CITY OF ALBUQUERQUE

November 5, 2019

**Re: 98th St./Bluewater Rd. NW
Erosion Sediment Control Plan
Engineer's Stamp Date 10/23/2019 (K09E041)**

INTERIM CONDITIONS DRAINAGE MAP

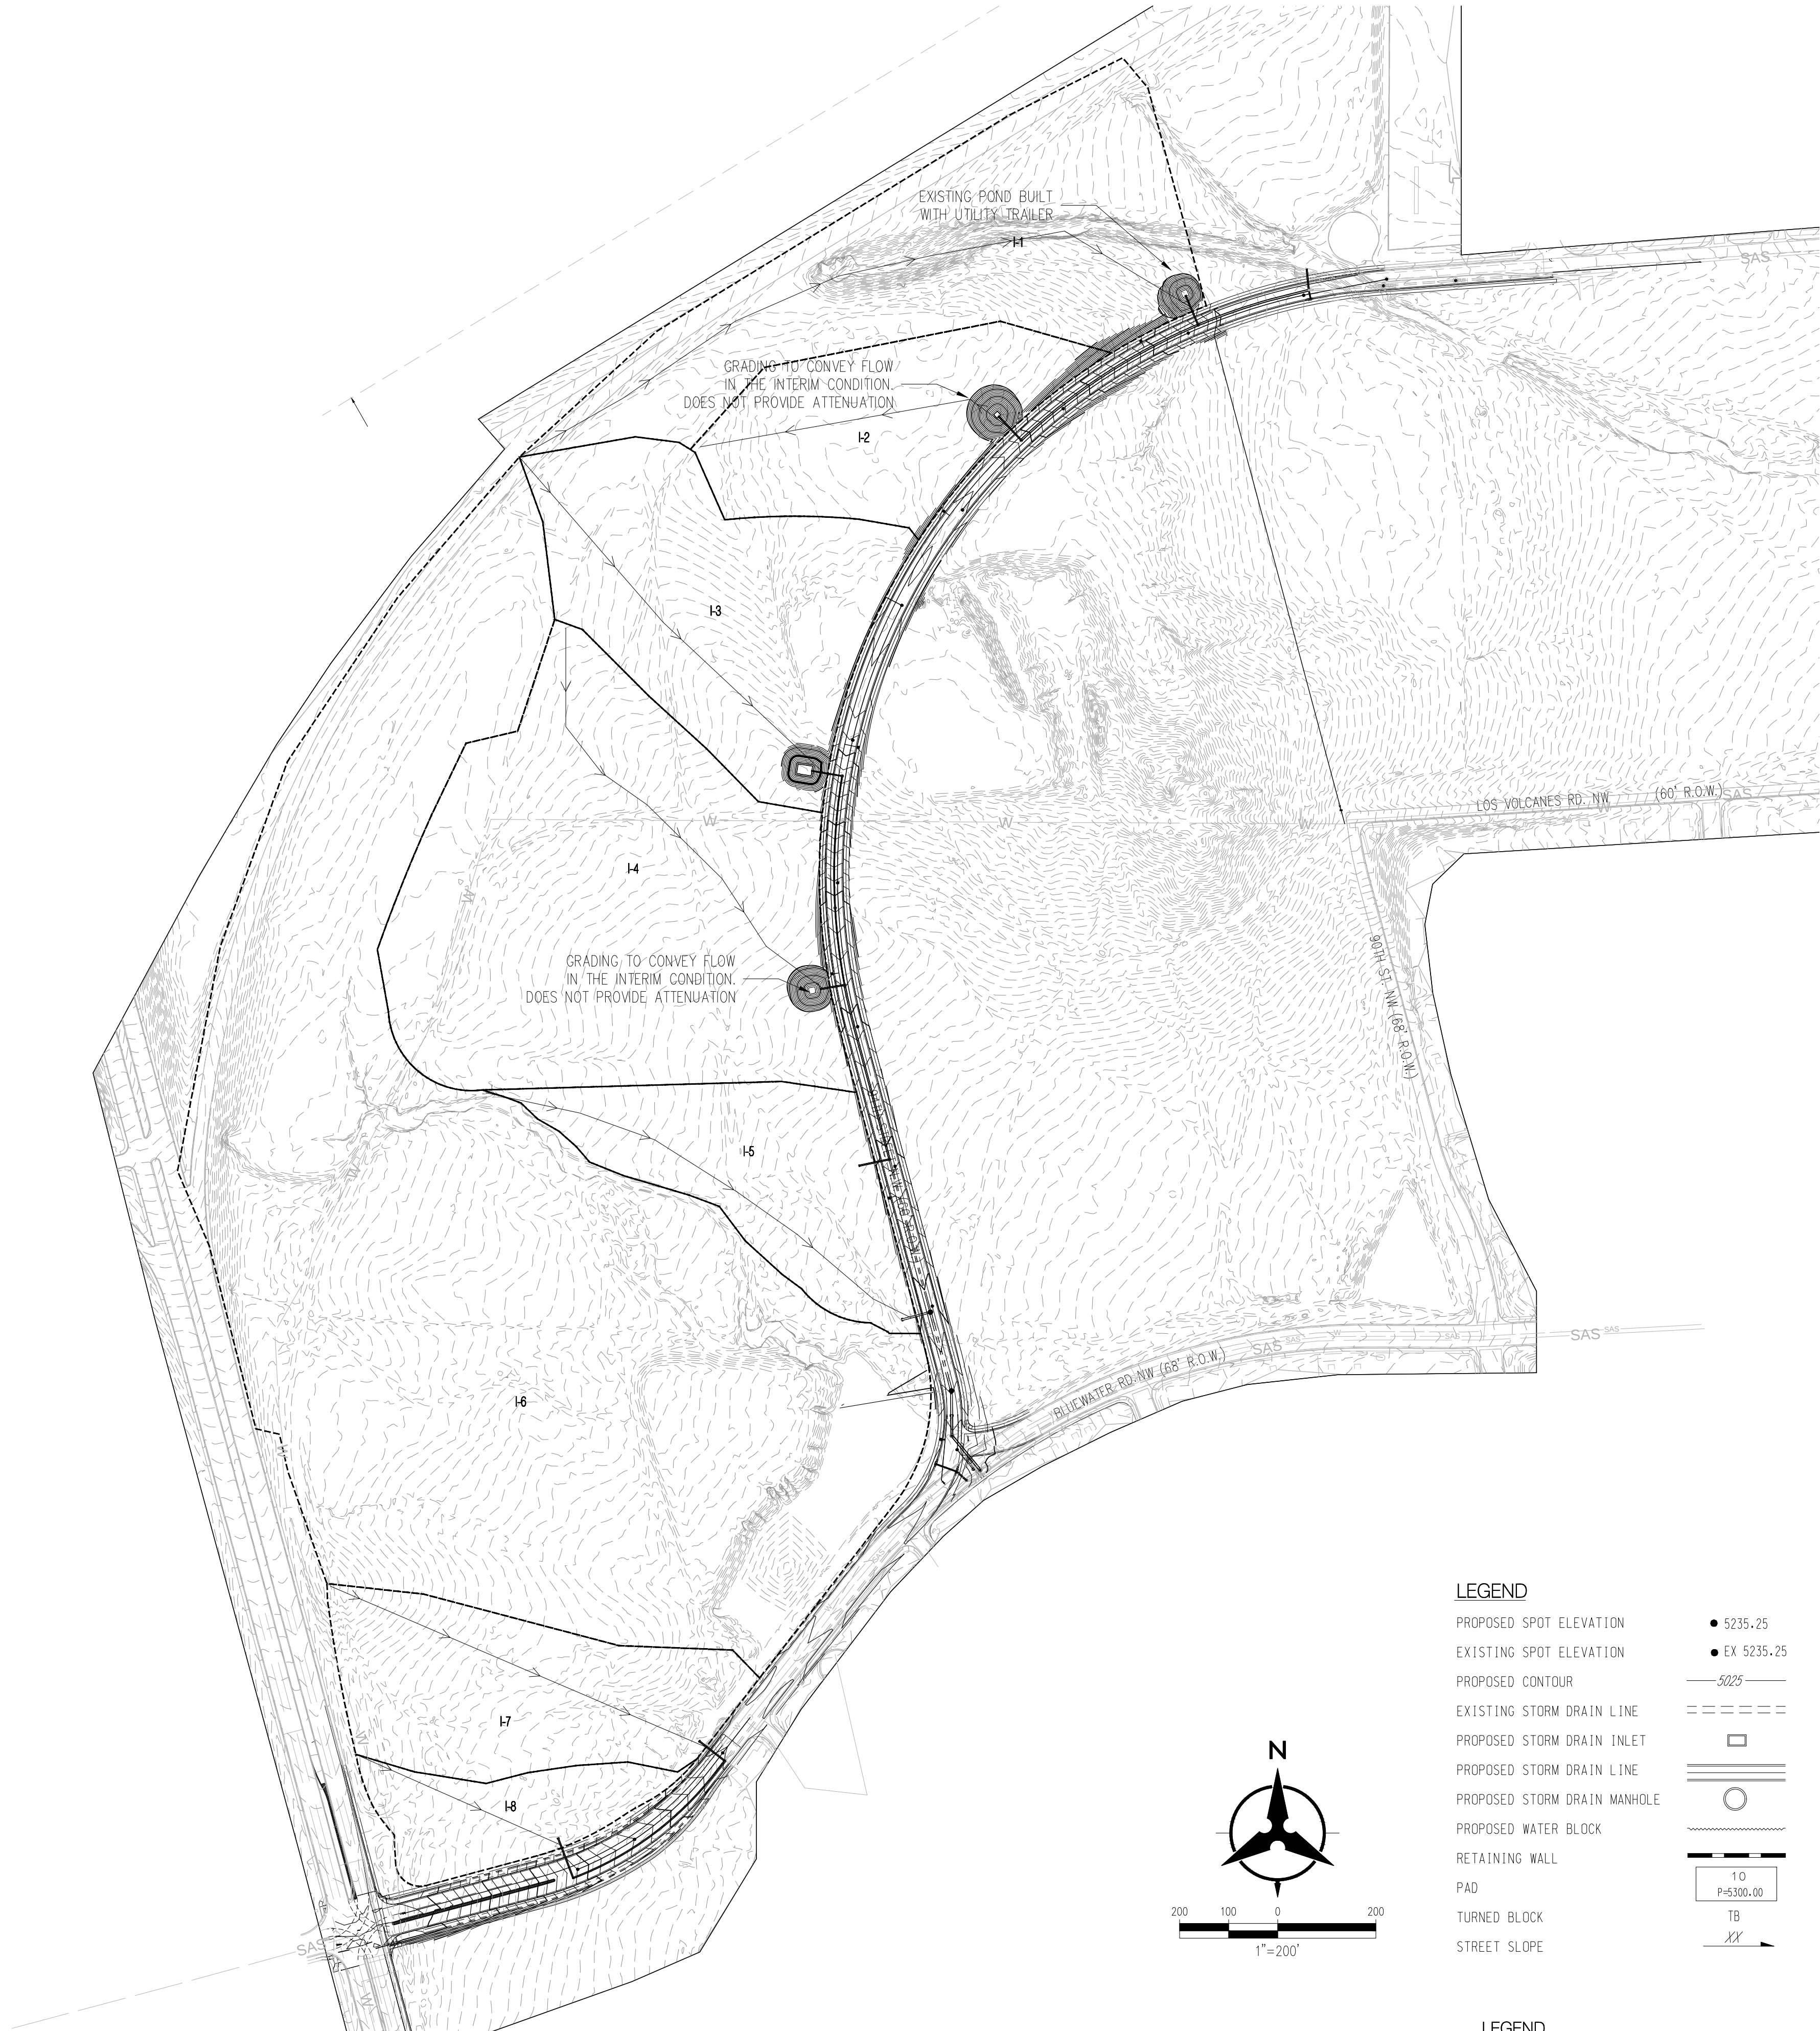
- Please clarify the limits of this project. The interim grading plan in the Work Order Plans shows a much larger area of grading. Also please show the existing and proposed contours.

- Please show berms as indicated on the interim grading plan, see note 8.
- Please add Sediment Basin(s) sized for the entire drainage area that contributes to it, both onsite and upstream offsite.
